From: Iain Osenton
Sent: 25 September 2019 17:06
To: Caroline Ford; Tim Screen
Subject: RE: 15/00138/DISC - Bicester Eco Town Exemplar Site Banbury Road Bicester

From: Tim Screen <Tim.Screen@Cherwell-DC.gov.uk>
Sent: 02 September 2019 16:23
To: Caroline Ford <Caroline.Ford@Cherwell-DC.gov.uk>
Subject: 15/00138/DISC - Bicester Eco Town Exemplar Site Banbury Road Bicester

North Frontage Soft Landscape Plan Final Scheme PL402 P04

South Frontage Soft Landscape Plan Final Scheme PL401 P05

PROJECT NO. ALD654	DRAWING NUMBER: PL402	REVISION: P04
-----------------------	--------------------------	------------------

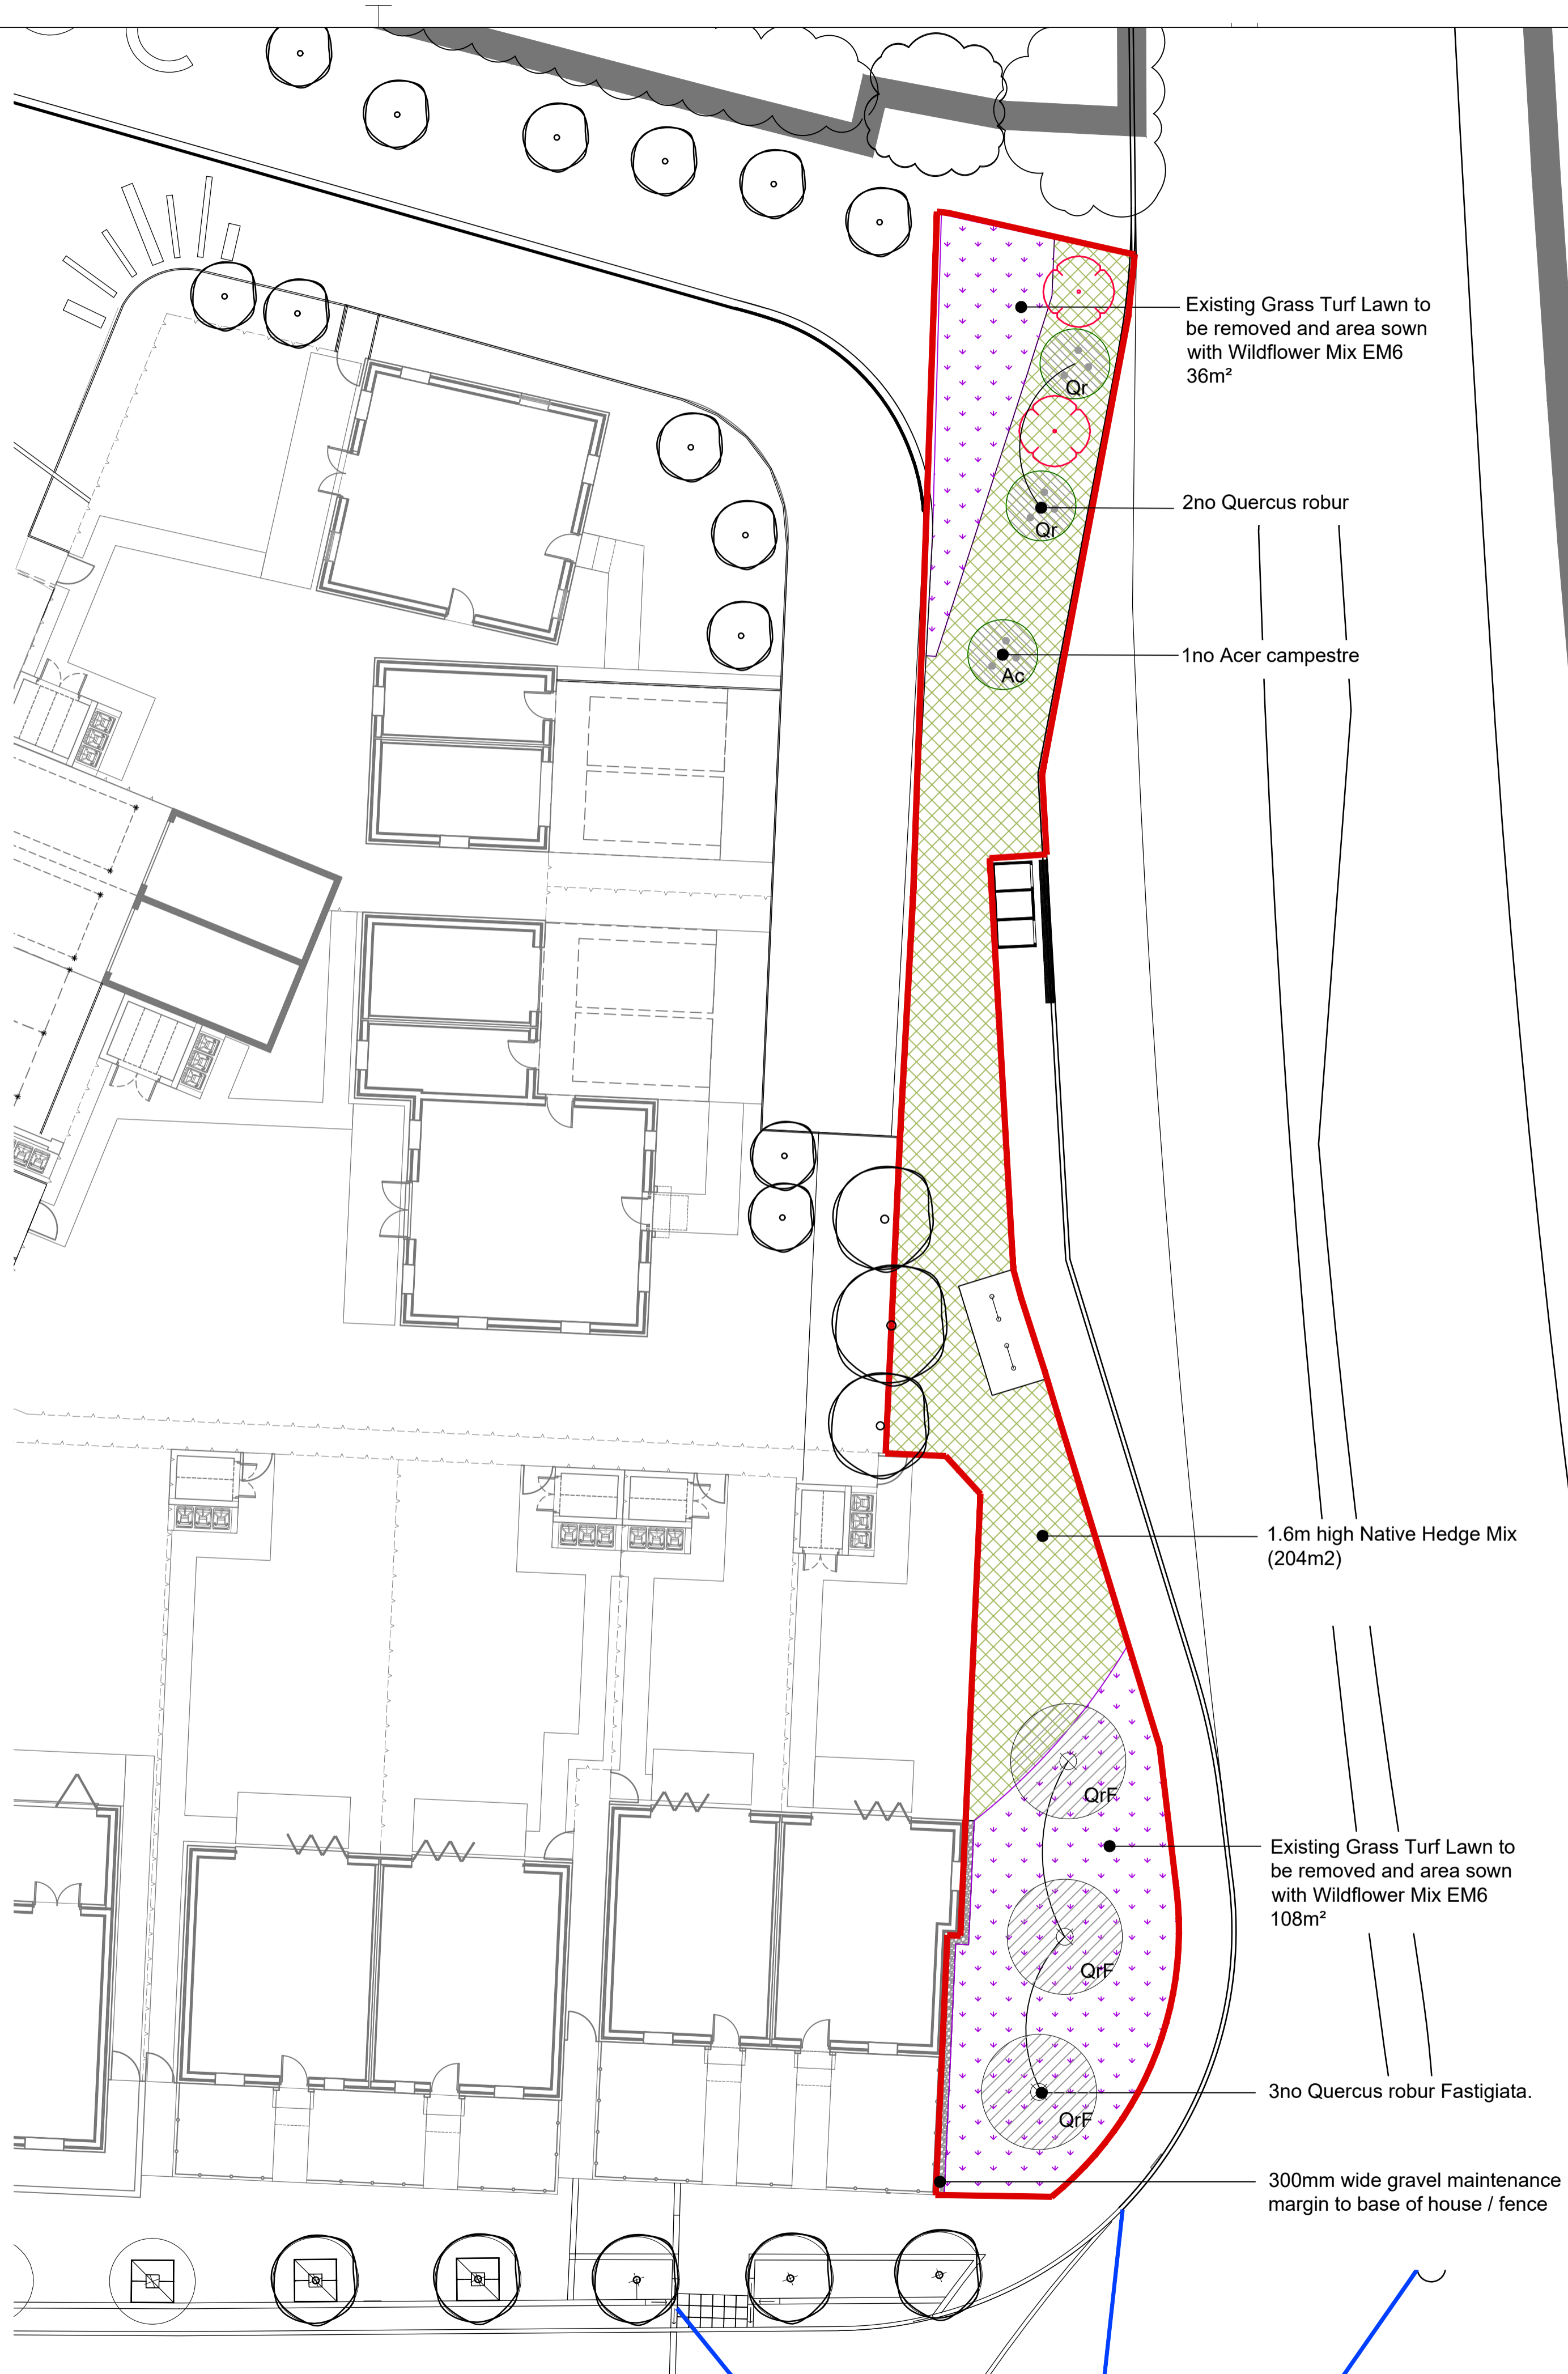
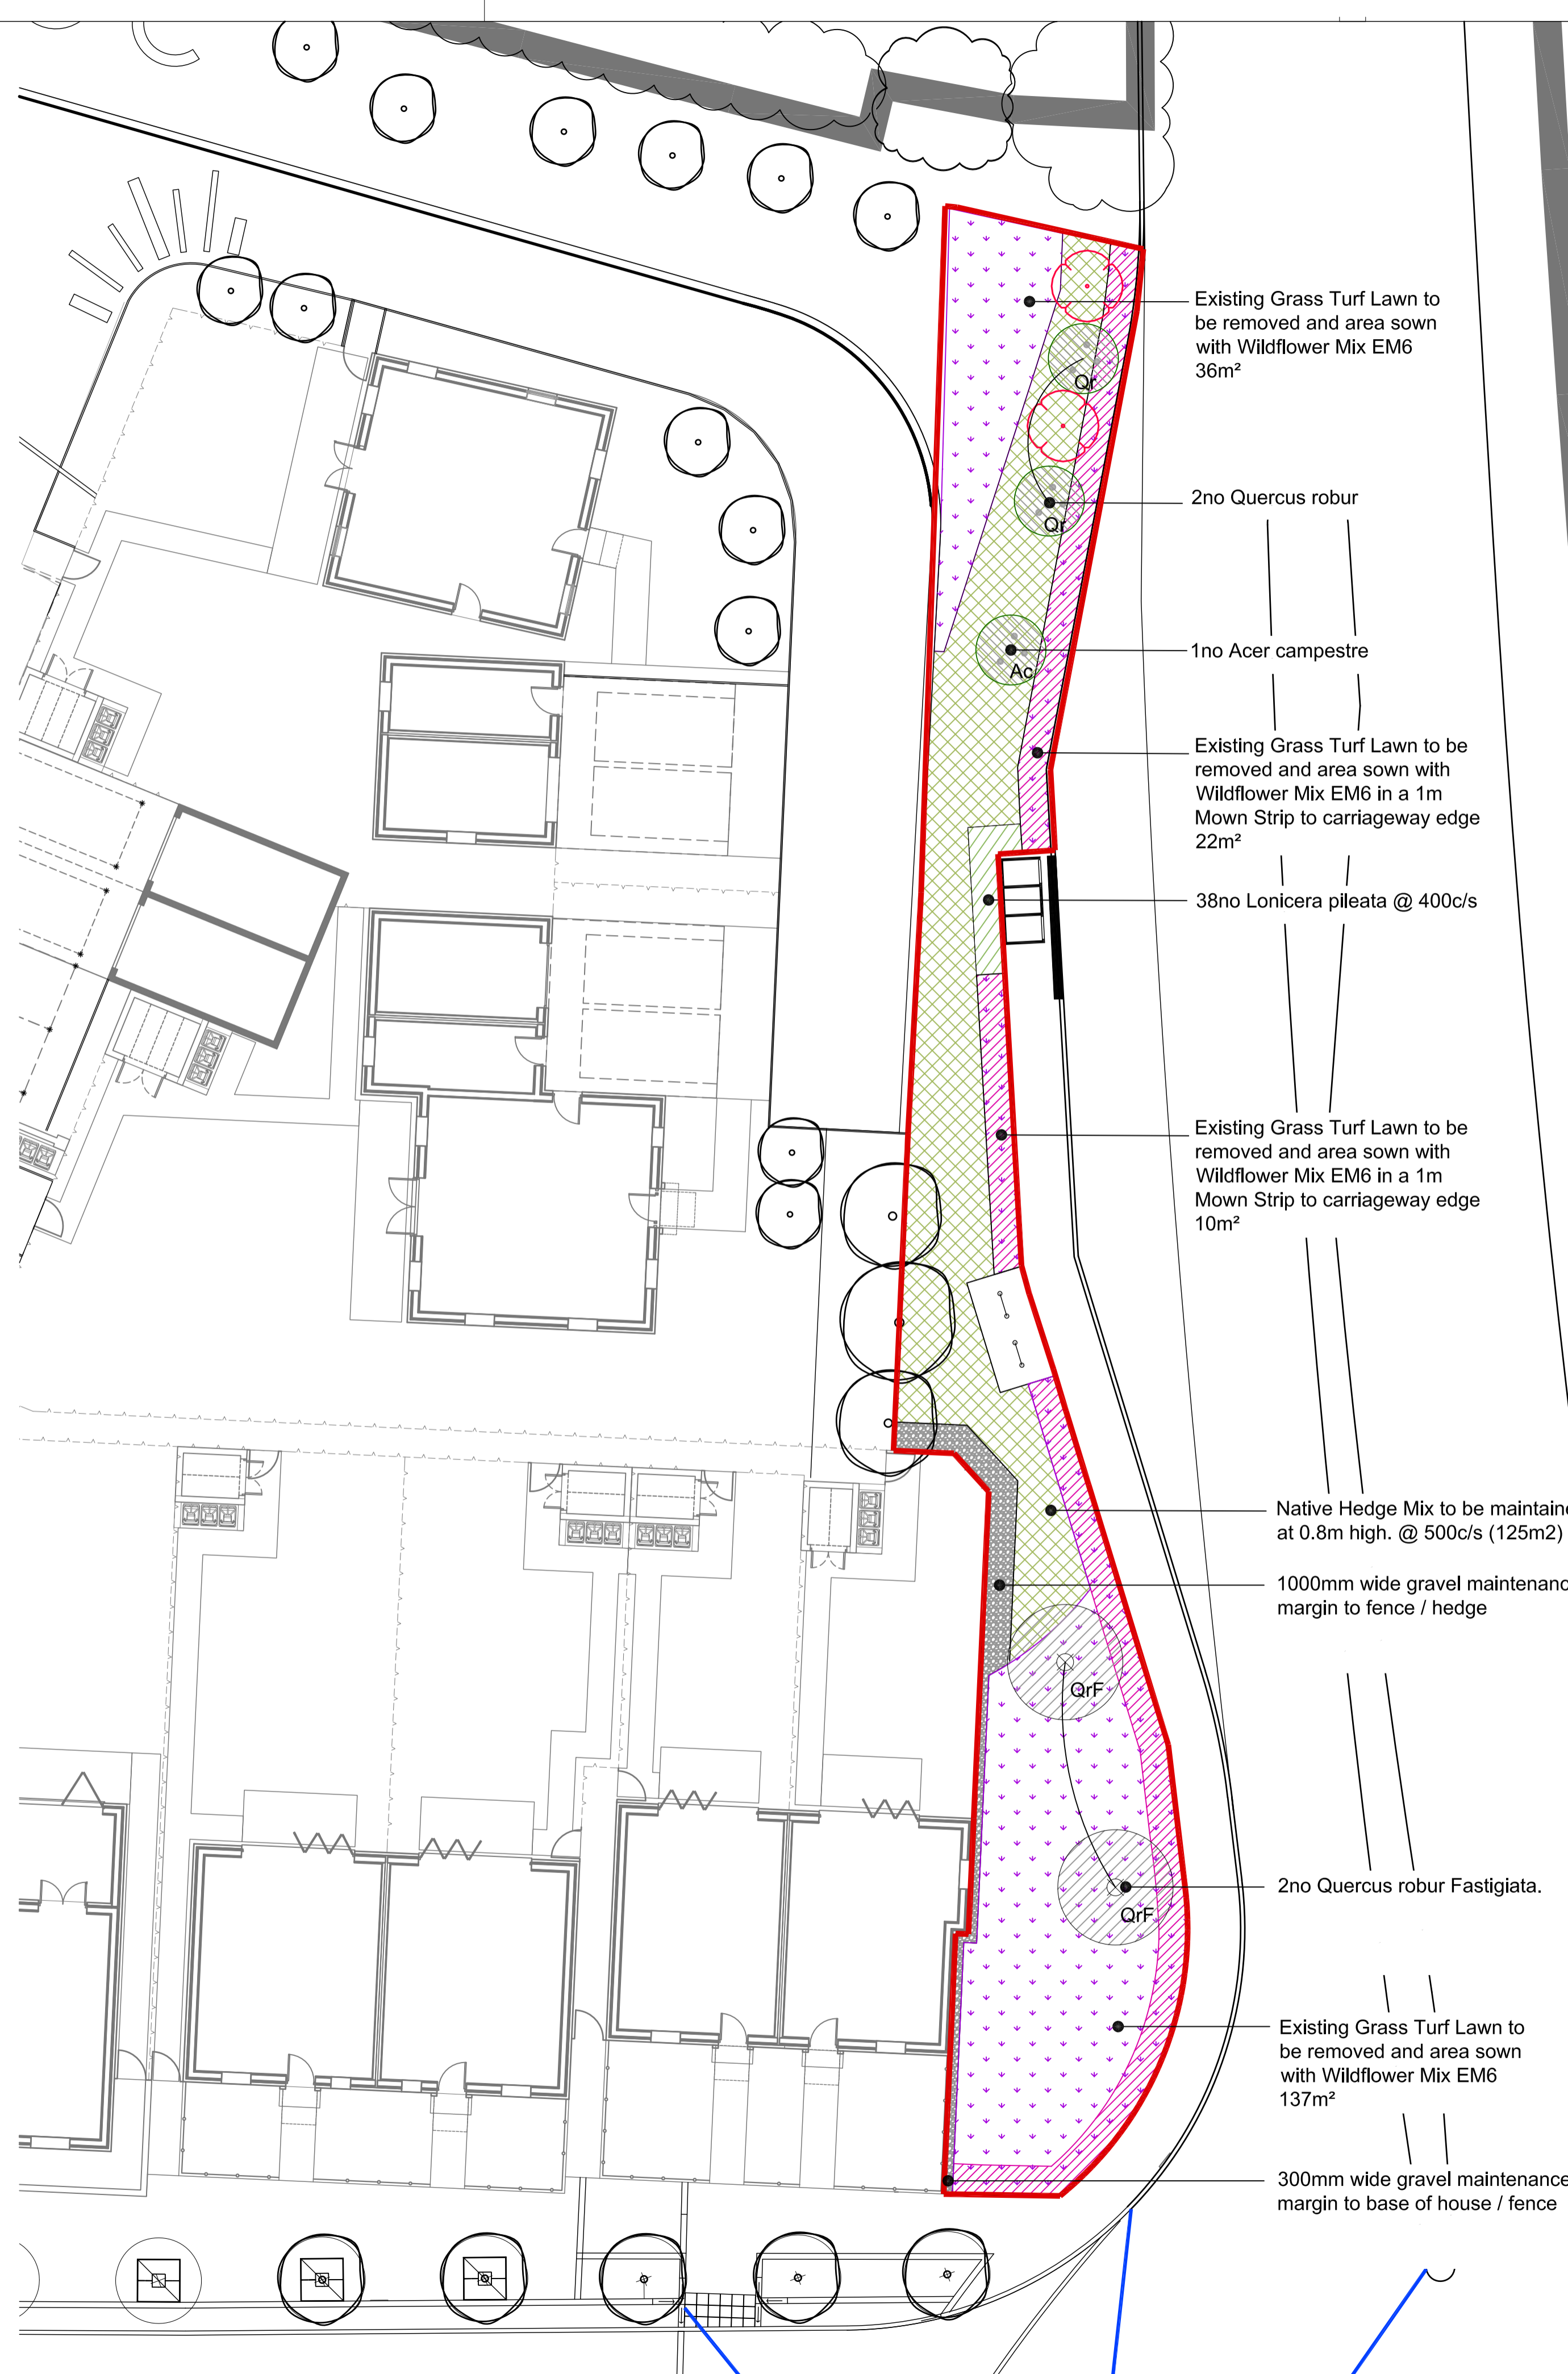
The 3 Fastigiata Oaks proposed for the north frontage are too close the dwelling's foundations. A structural engineer should advise of the appropriateness of these trees. Soil shrinkage may occur and building foundations fail. In order to reduce this risk (reduce the water uptake) the central tree should be deleted and remaining trees re-positioned to align with the walls of the adjacent dwelling; positioned 8 m apart and 4 m from the foundations (vis-splay permitting).

The hedgerow mix planting abuts the edge of the footpath and the road. The overgrowing stems will impede people's access along the footpath.

I would suggest that a 1m wide mown grass verge is incorporated between the footpath to the bus stop and the edge of the mix, and also the road and the mix.
